03 January 2020

**Re: Technical Review Response to 12/10/2019 Letter  
Project Rodeo  
City of Colorado Springs, El Paso County, Colorado  
Langan Project No.: 620011104  
AR DP 19-00633, AR NV 19-00634, AR NV 19-00635**

Project No. 620011104	Drawing No. DP CS100 0101
Date 10/04/2019	
Drawn By DTF	
Checked By DB	Sheet 3 of 66

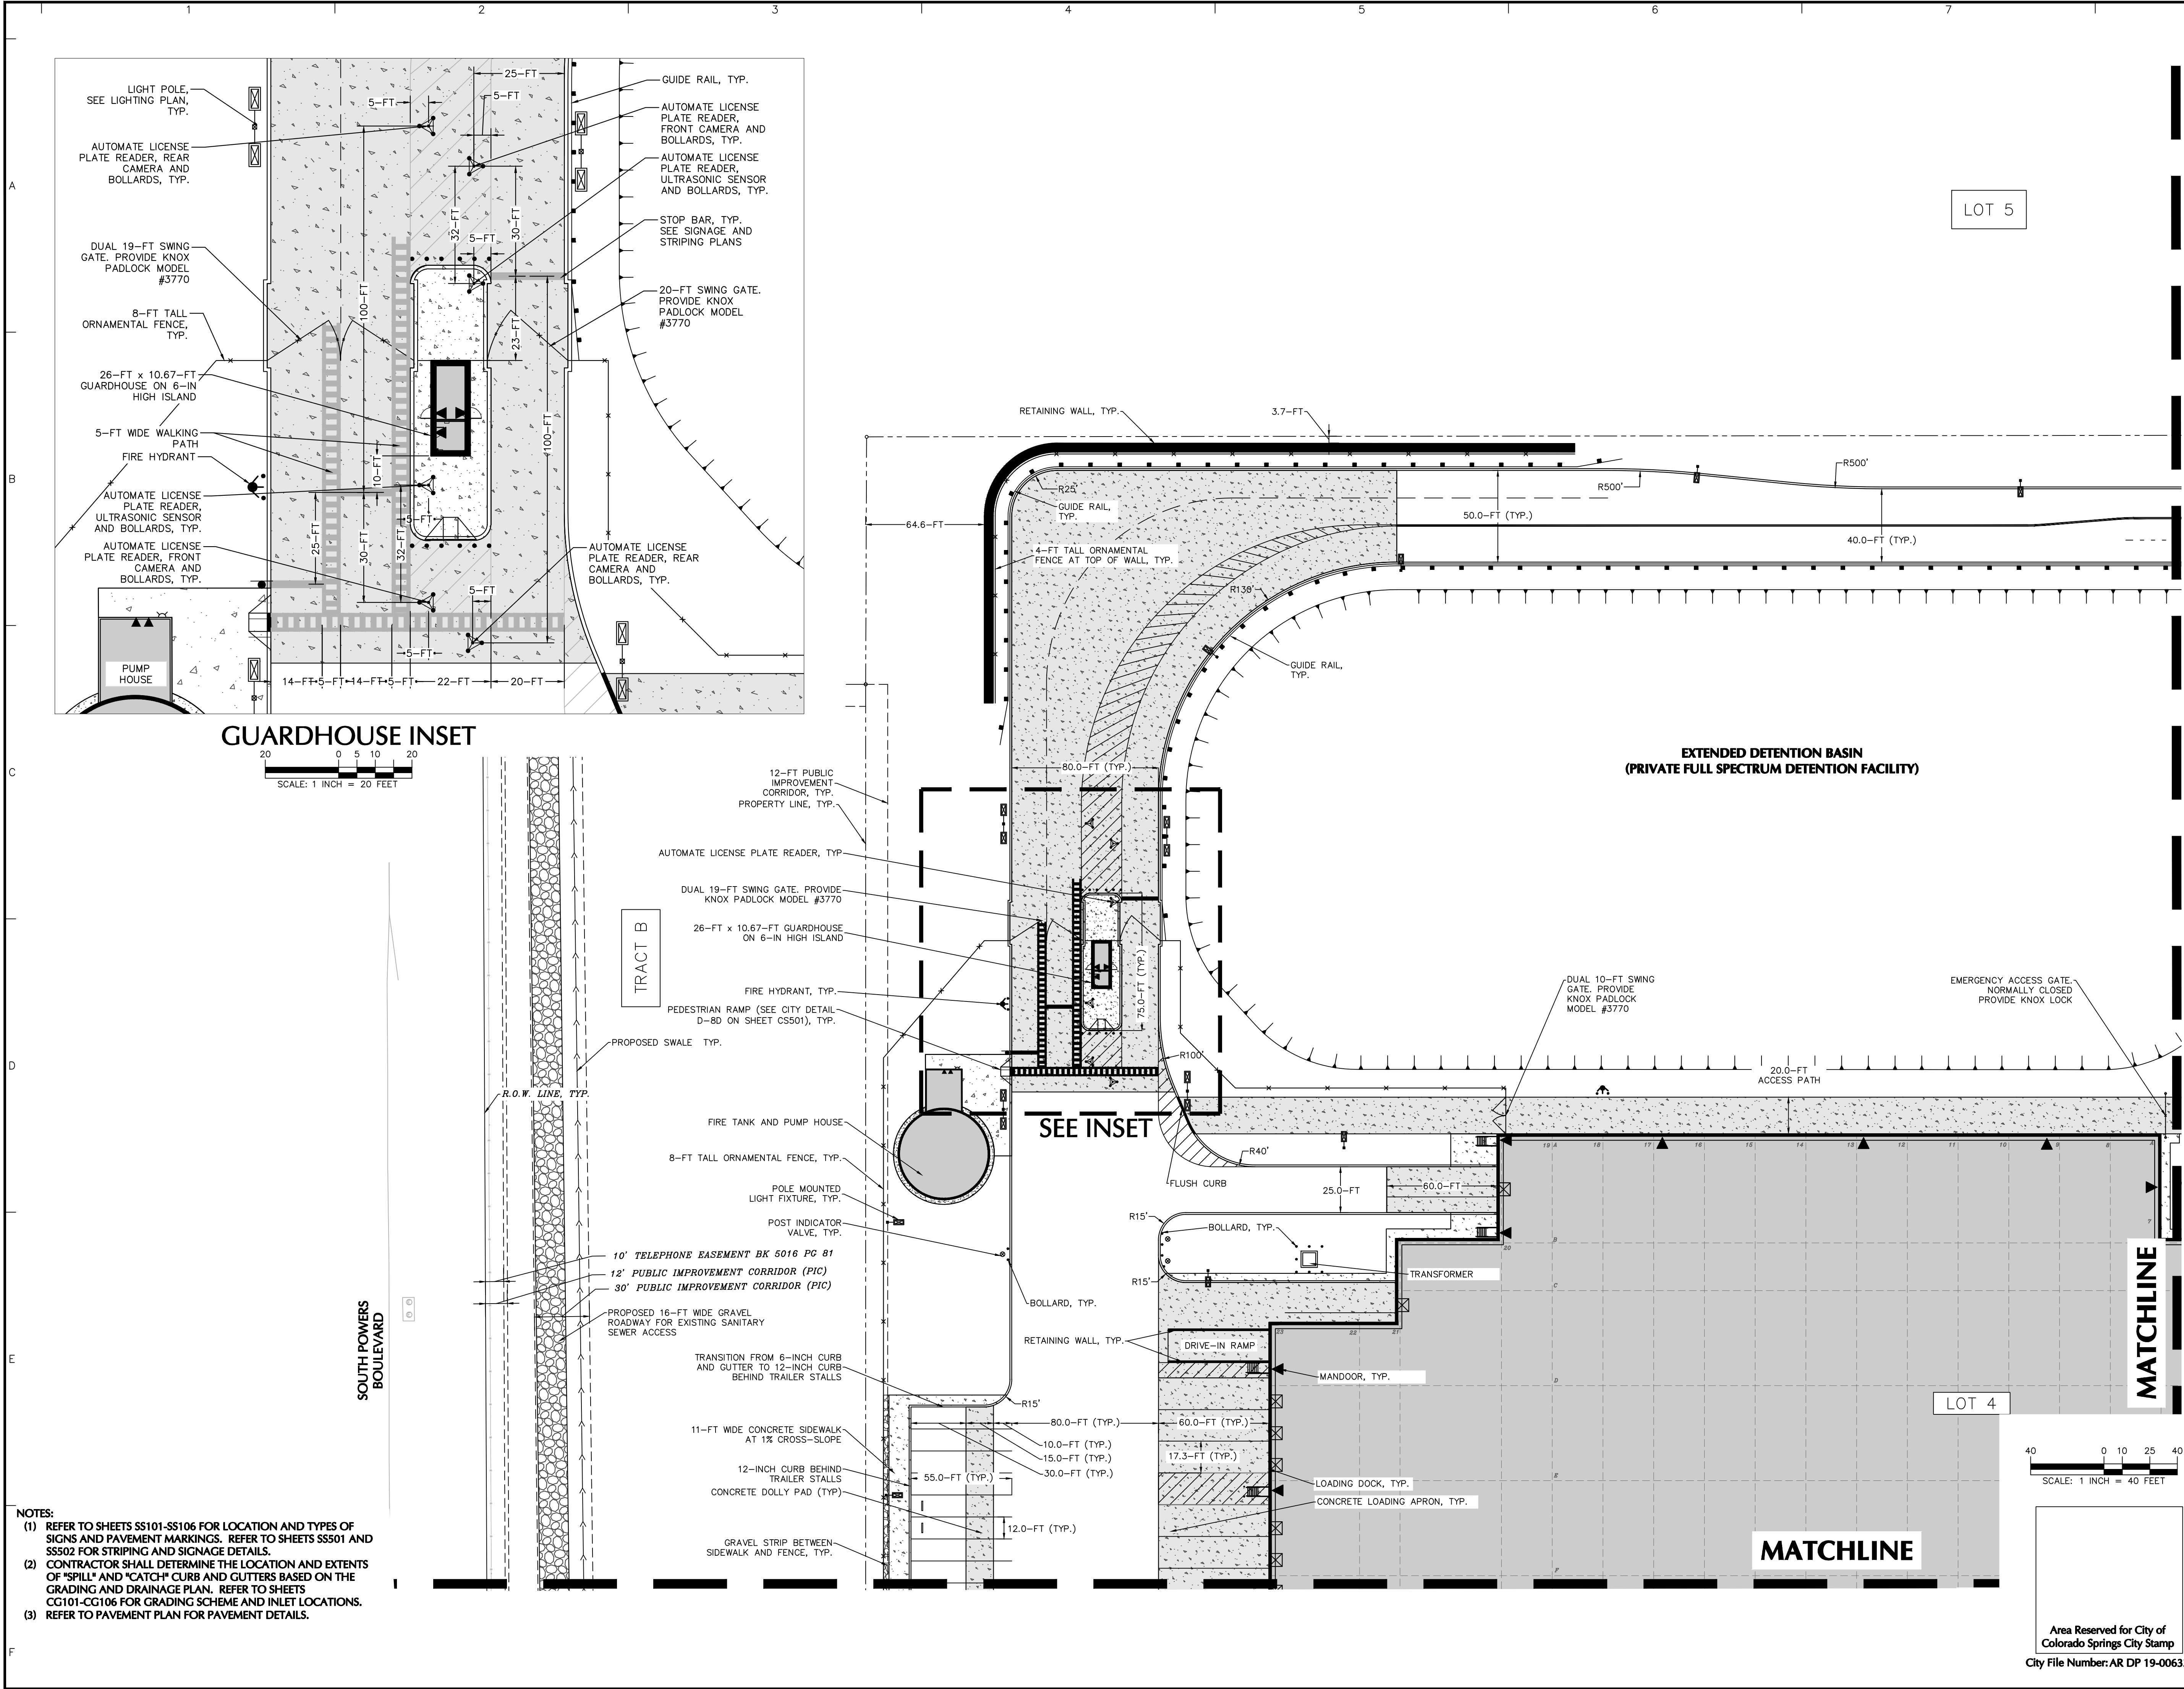
1. *Sheet 1*
  - a. *Update legal description, the property equates to 69.247 Acres not 69.252 Acres. See attached legal.*

- b. *Development Plan Size under the Site Data should be 69.247 AC*

**Response: Legal description has been updated to reflect the revised acreage.**

**Response: Acreage has been revised to be 69.247 ac.**

**PARTIAL
FINAL
LANDSCAPE PLAN
5**

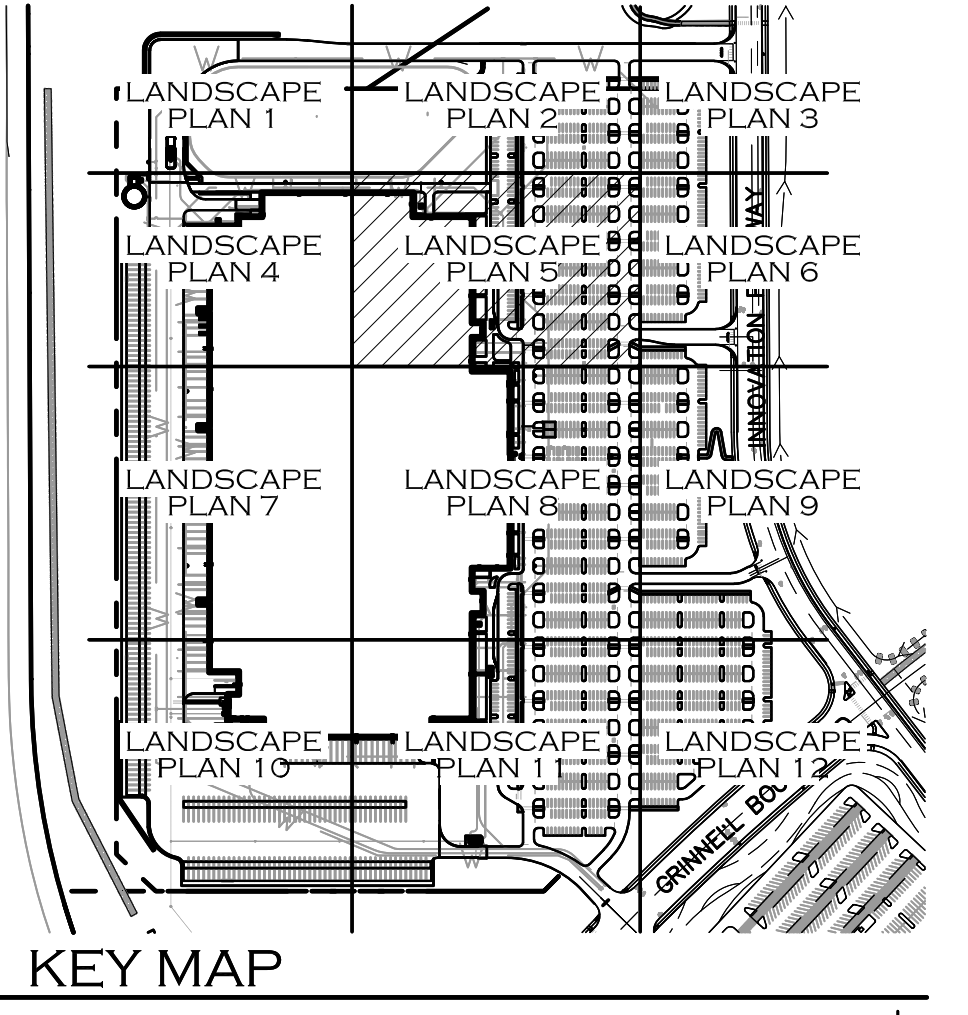
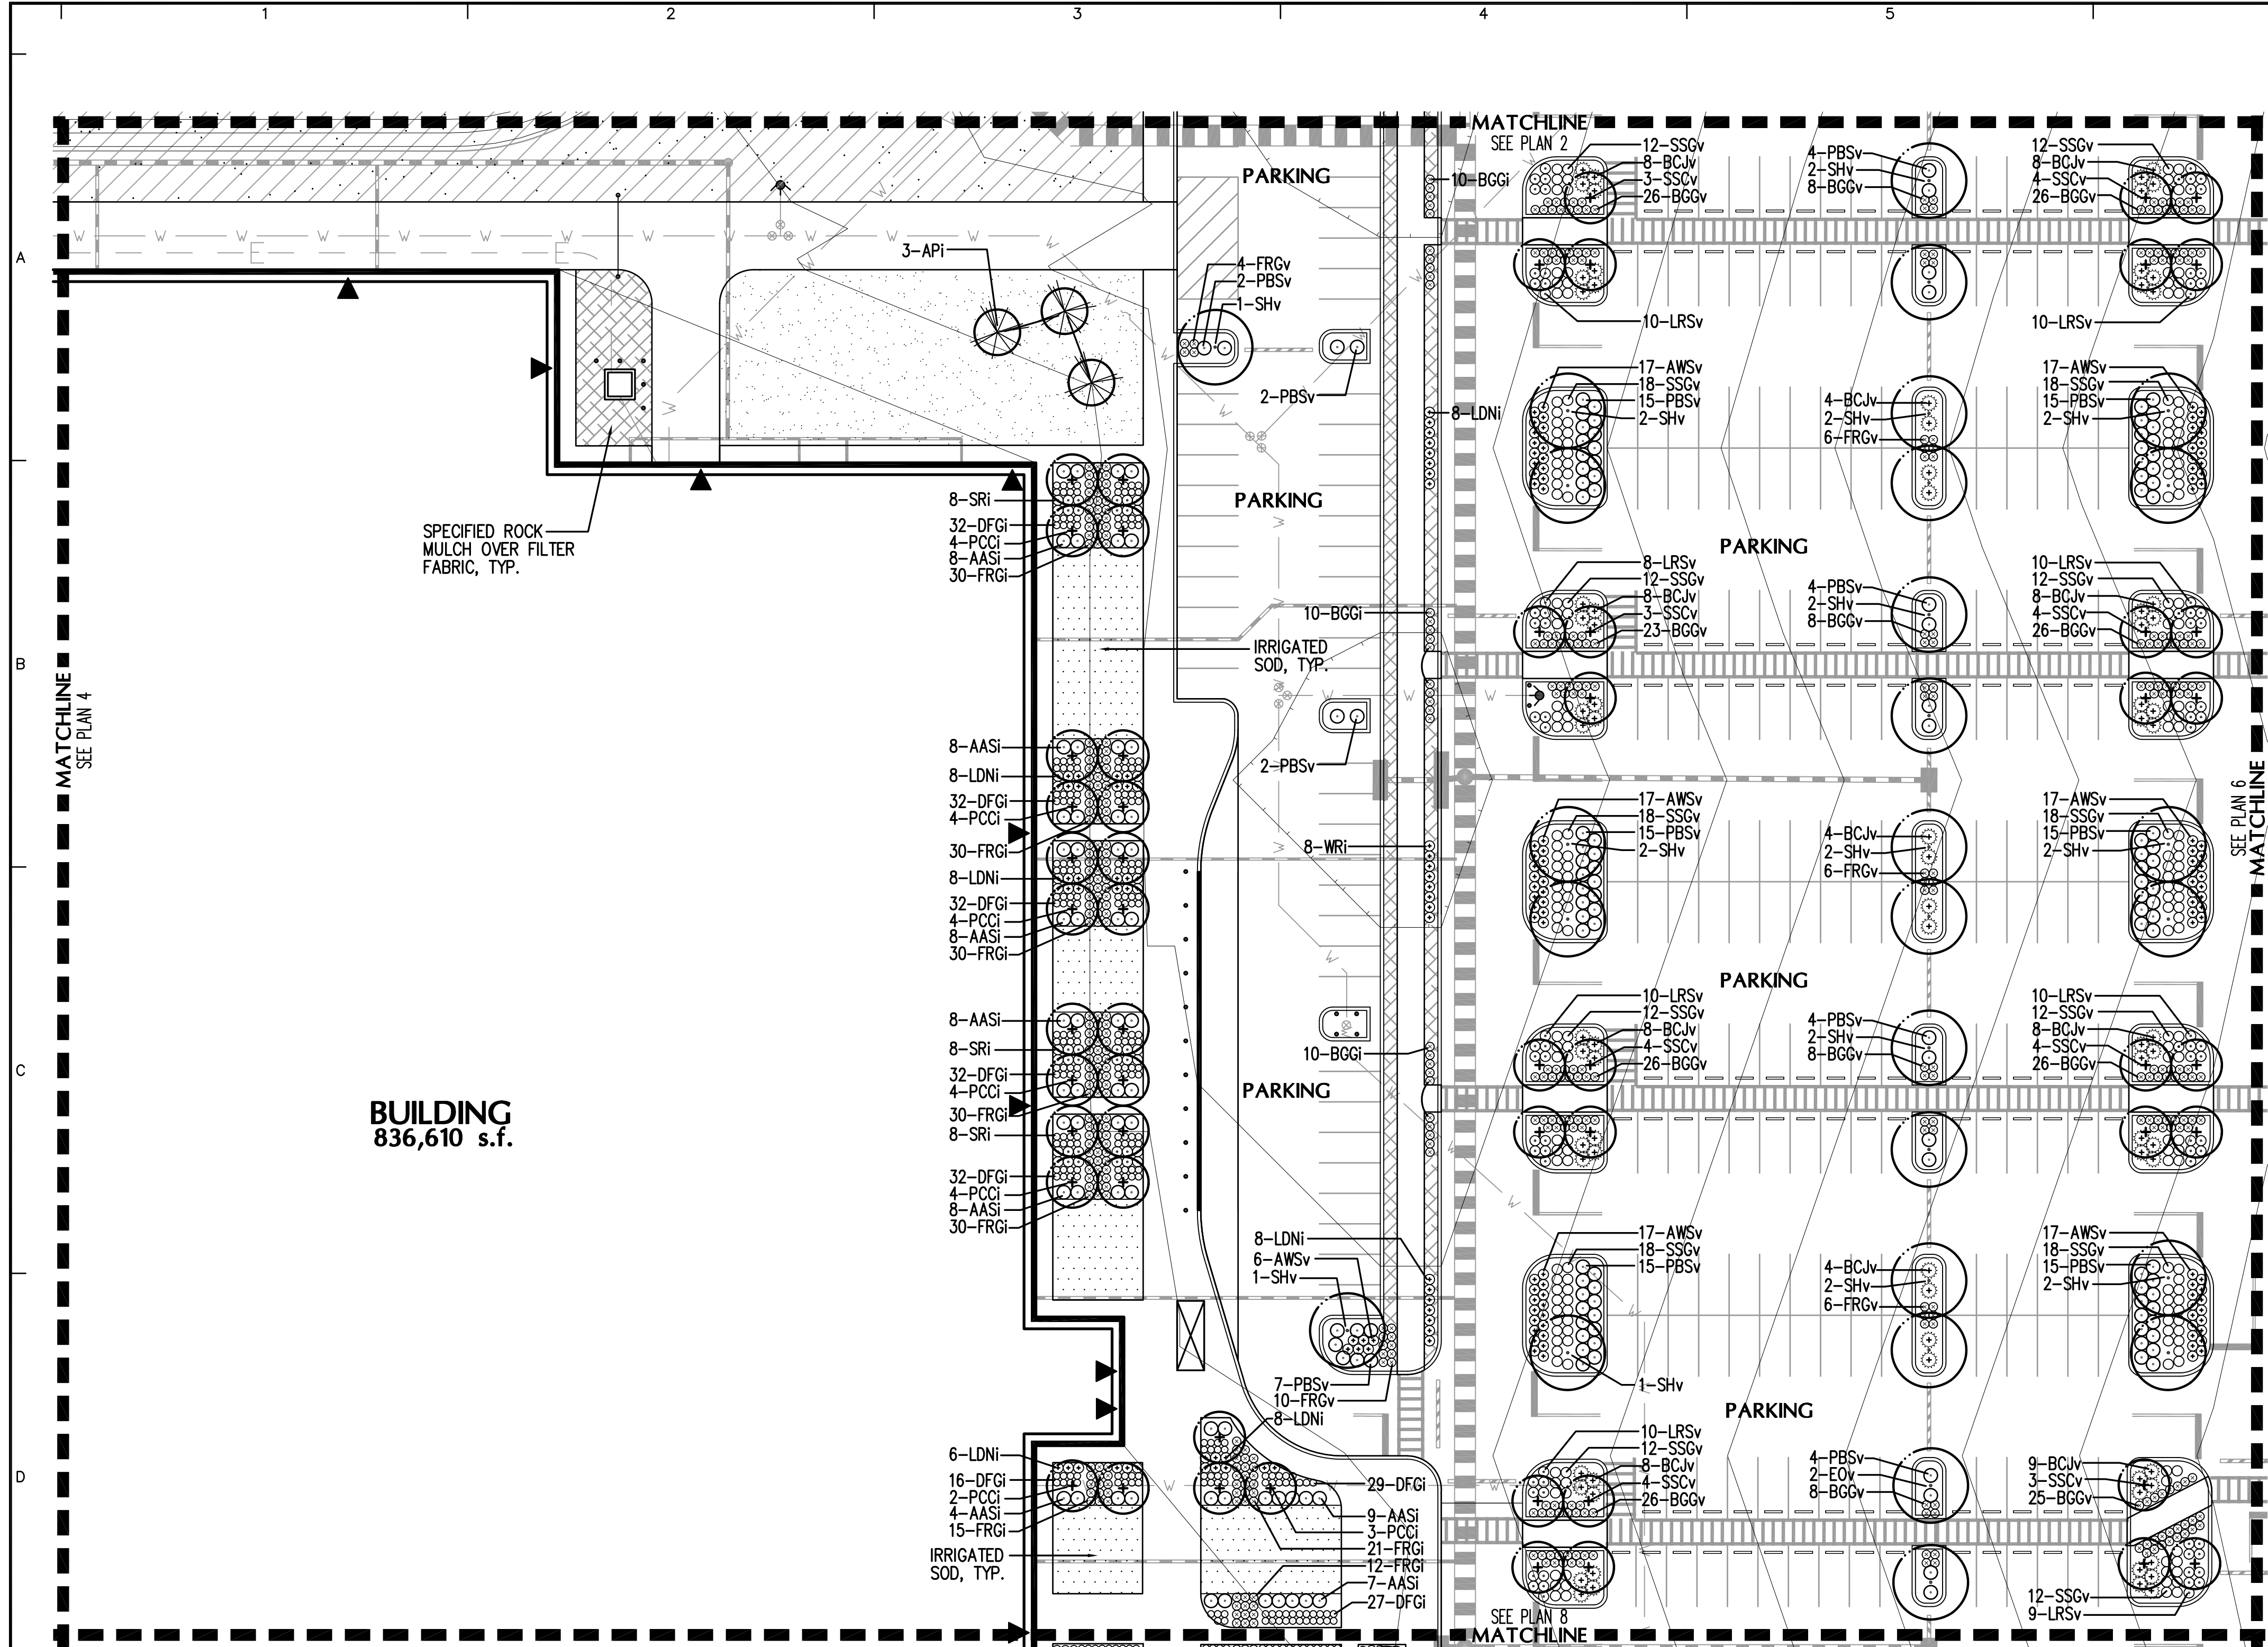
- a. *Building square footage of 836,610 differs from the square footage identified on sheet 3 of 823,173. Please update.*

**Response: Building footprint square footage has been updated on all sheets.**
